Ribble Valley Borough Council
By email

Your ref 3/2024/0544
Our ref DC/24/1788
Date 06-AUG-24

Location: The Old Garage Site Newton Road Dunsop Bridge BB7 3BB

Proposal: Proposed provision of GRP Substation to house ENWL infrastructure, plant room building, alterations to site layout including repositioned bin store, cycle store and boundary treatment alterations

Drawing title	PROPOSED SITE PLAN & BLOCK PLAN
---------------	------------------------------------

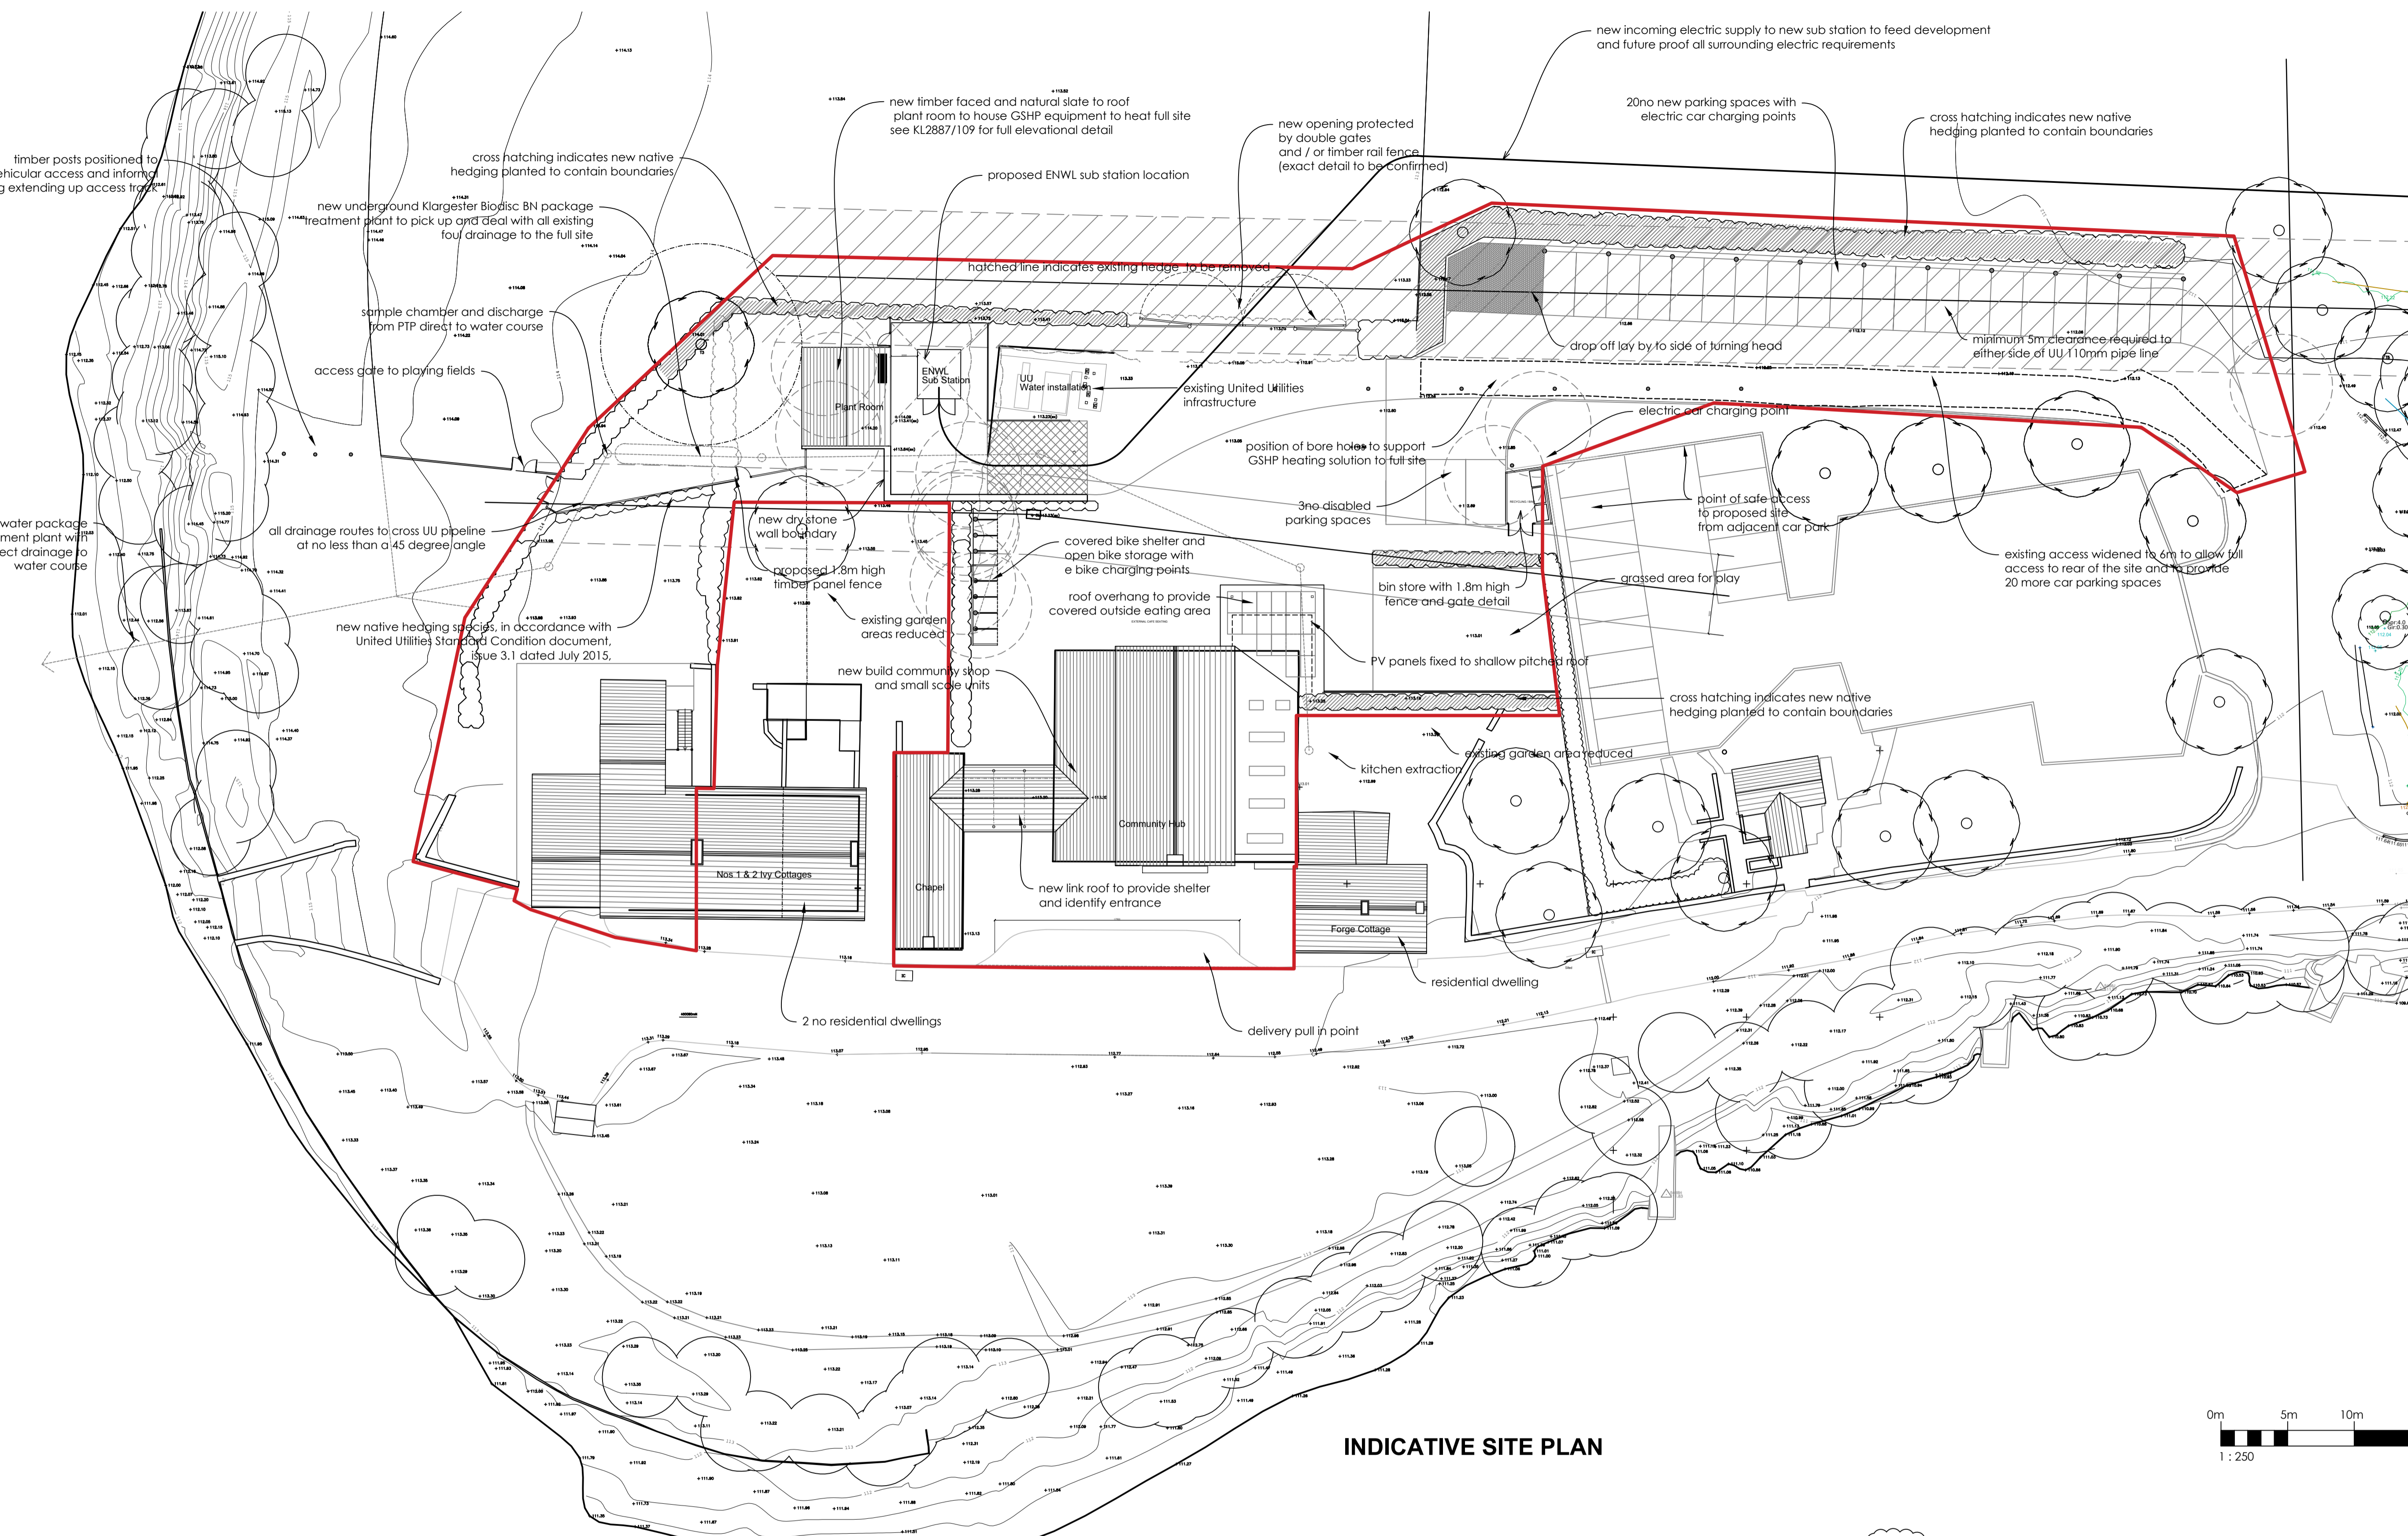
Water mains cross the site and a water pumping station is located in the vicinity of the site. They must not be built over, or our access to the pipeline or pumping station compromised in any way. We require an access strip as detailed in our 'Standard Conditions for Works Adjacent to

Referring to the above, we still need to clearly see what protection measures the applicant proposes at a more detailed design stage for the assets crossing the site and the relationship with the proposal as it is delivered. We therefore request the following condition is included in the subsequent Decision Notice to afford appropriate protective measures for our water infrastructure in the site:

As noted above, United Utilities land (title number LAN227970) is within the application site. The plans do not appear to affect this land though it is the responsibility of the developer to ensure that no development occurs within the United Utilities land and access thereto is not prohibited.

As noted above, water mains cross the site and a water pumping station is located in the vicinity of the site. They must not be built over, or our access to the pipeline or pumping station compromised in any way. We require an access strip as detailed in our 'Standard Conditions for Works Adjacent to Pipelines', which can be found on our website [standard-conditions-for-works-adjacent-to-pipelines-issued-july-2015.pdf \(unitedutilities.com\)](https://www.unitedutilities.com/standard-conditions-for-works-adjacent-to-pipelines-issued-july-2015.pdf)

No construction shall commence (including any earthworks) until details of the means of ensuring the water main infrastructure that is laid within the site boundary is protected from damage as a result of the development have been submitted to and approved by the Local Planning Authority in writing. The details shall include a survey that identifies the exact location of the infrastructure, the potential impacts on the water mains from construction activities (including the construction compound), the impacts post completion of the development on the infrastructure that crosses the site and identify mitigation measures, including a timetable for implementation, to protect and prevent any damage to the infrastructure both during construction and post completion of the development.

Any mitigation measures shall be implemented in full prior to commencement of development in accordance with the approved details and timetable and shall be retained thereafter for the lifetime of the development. In the event that the survey of any water main infrastructure identifies the development within a 3m standoff either side of the main (6m in total), the developer shall submit evidence to the Local Planning Authority that a diversion has been agreed with the relevant statutory undertaker and that the approved works have been undertaken prior to the commencement of development.
